Project Title: Chick-fil-A at Gibson Building Permit #: _____ City Drainage #: _____

Re: **Chick-fil-A**
1600 Gibson Blvd. SE
Grading and Drainage Plan
Engineers Stamp Date 12/15/14 (M12-D015C)

Merrick & Company has reviewed the comments received on February 26, 2015 regarding the proposed Chick-fil-A located at 1600 Gibson Blvd. SE. The following summarizes Merrick's response to the comments provided by the City of Albuquerque.

Date :07/01/15

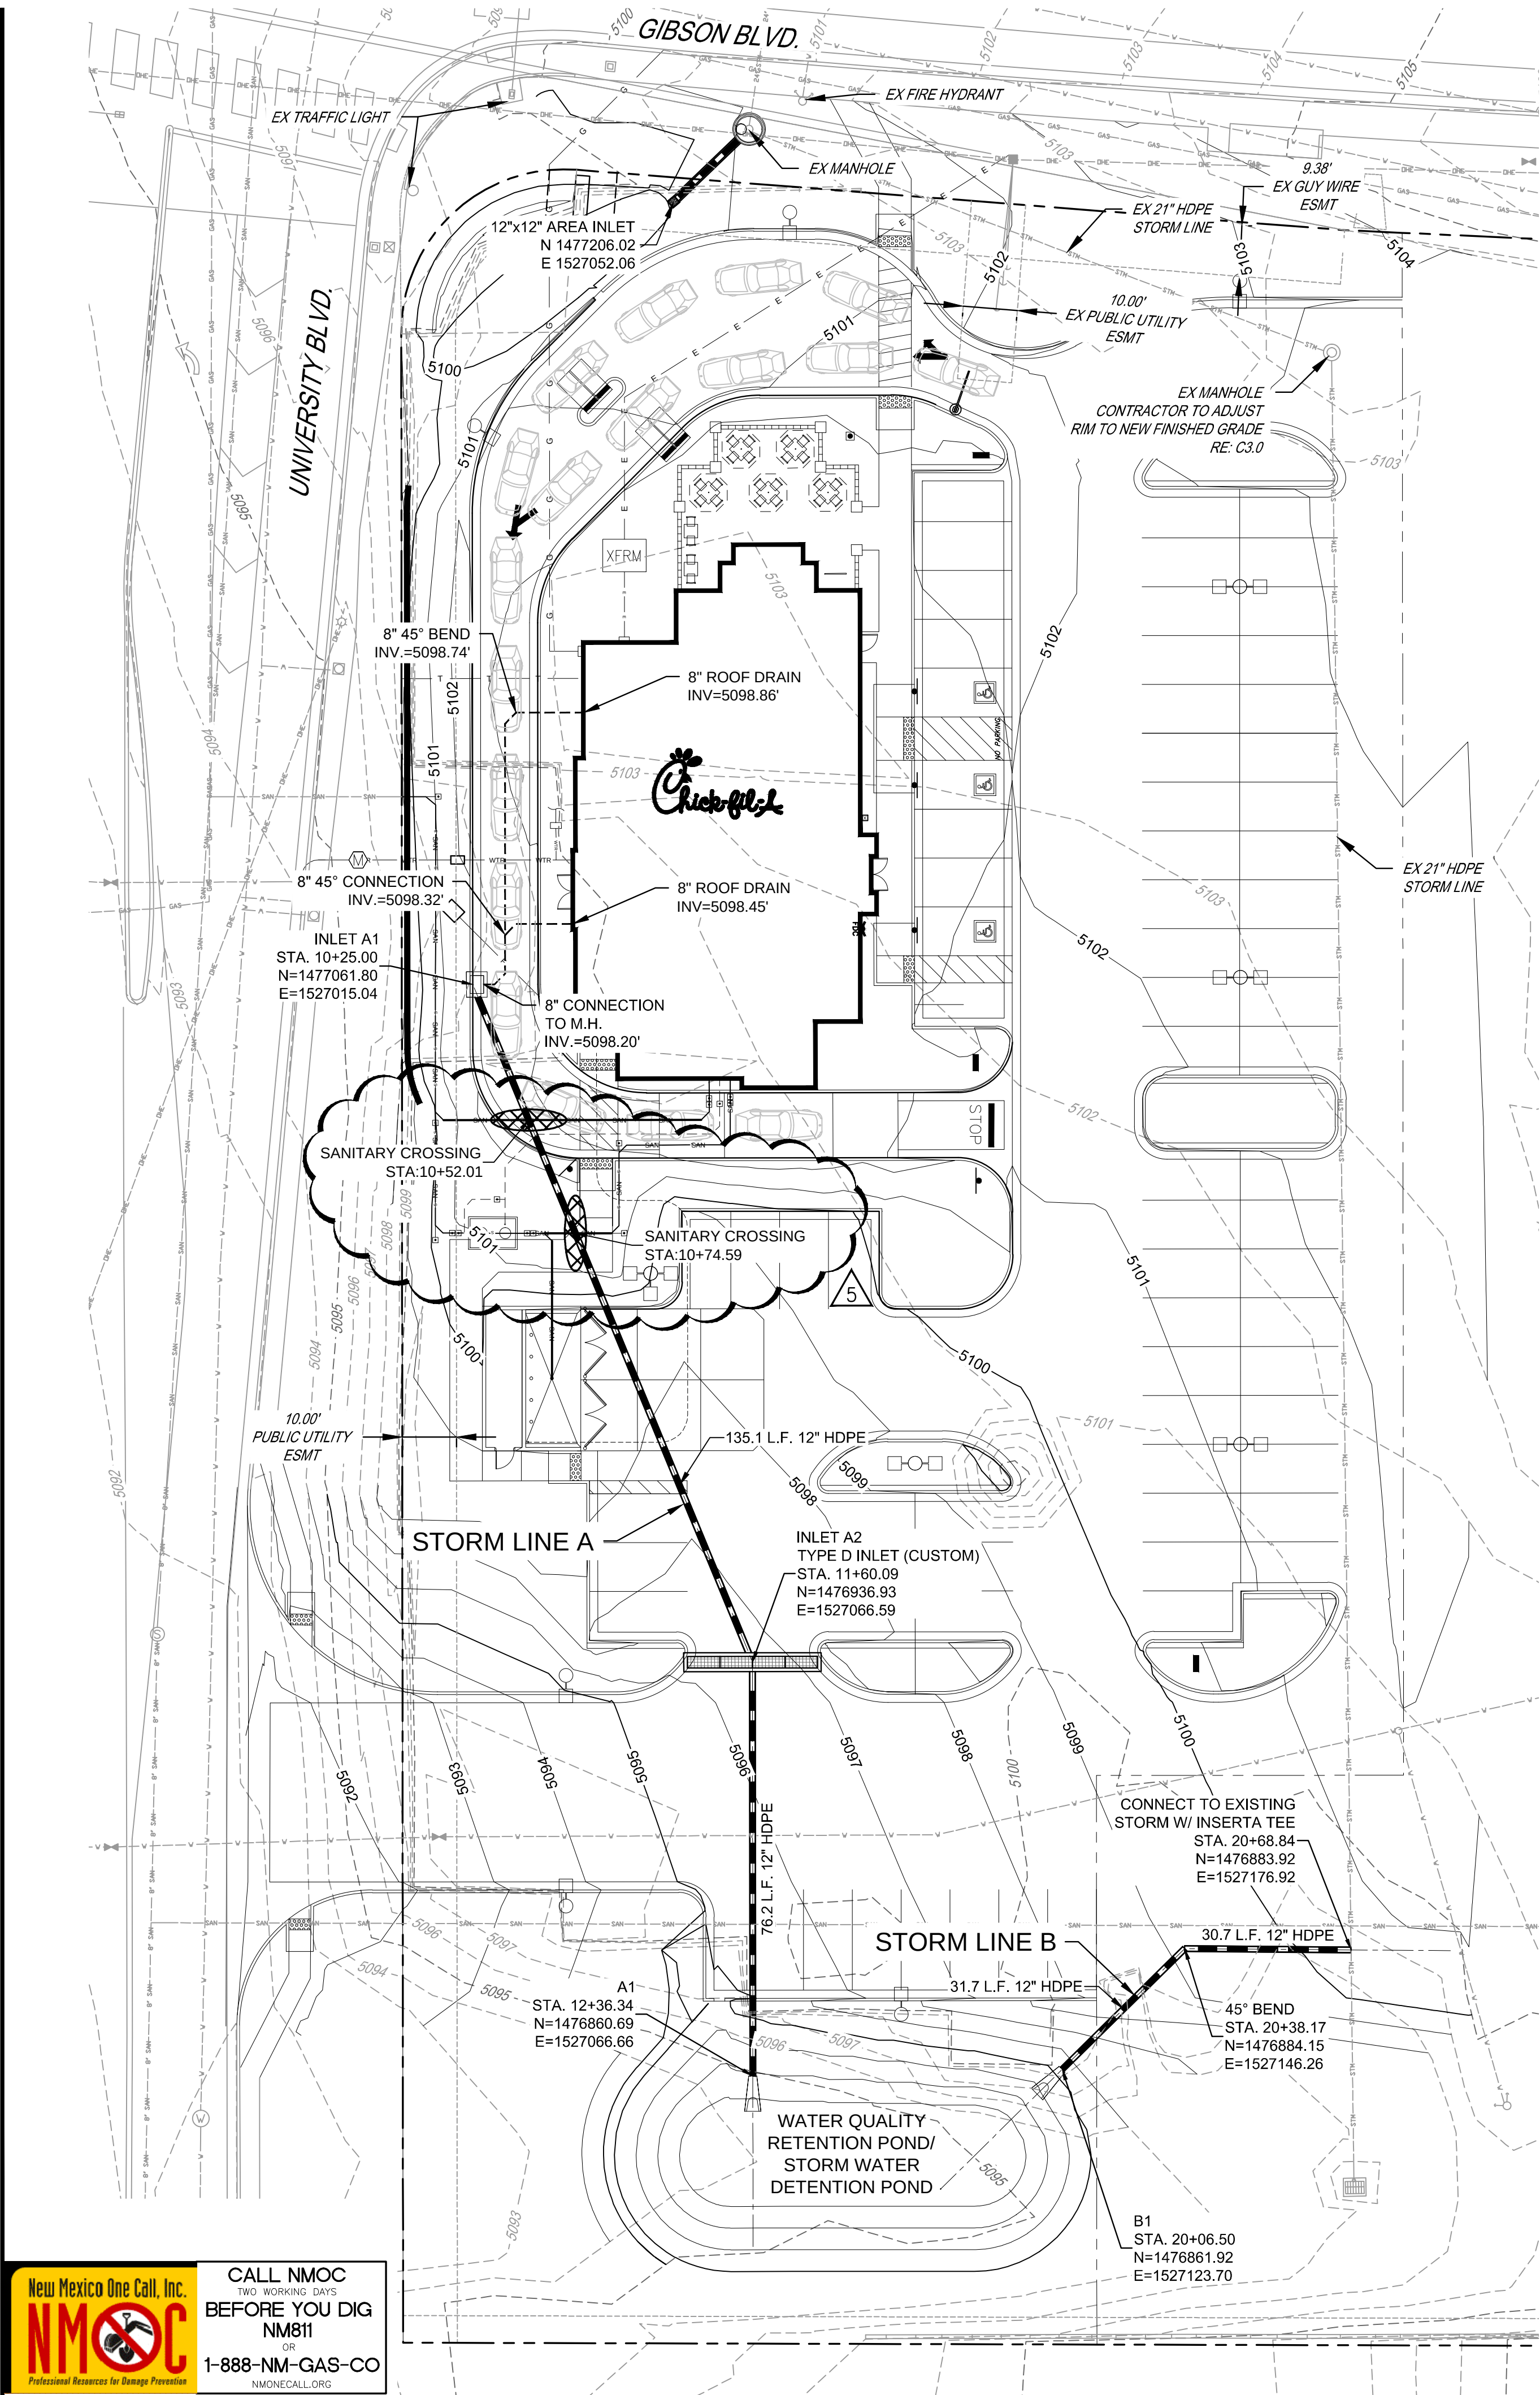
- Mention of the first flush per EPA standards is required. The amount required is .34" times the impervious area. We believe there is enough landscape area to accomplish this requirement.

- Show the roof flows.

- Basin B-1 needs to flow through a first flush retention pond before leaving the site.

Response: The first flush has been mentioned in the drainage statement located on sheet C-3.2.

Response: Roof flows have been added to the drainage map.

Response: A retention pond has been added to retain the first flush from basin B-1
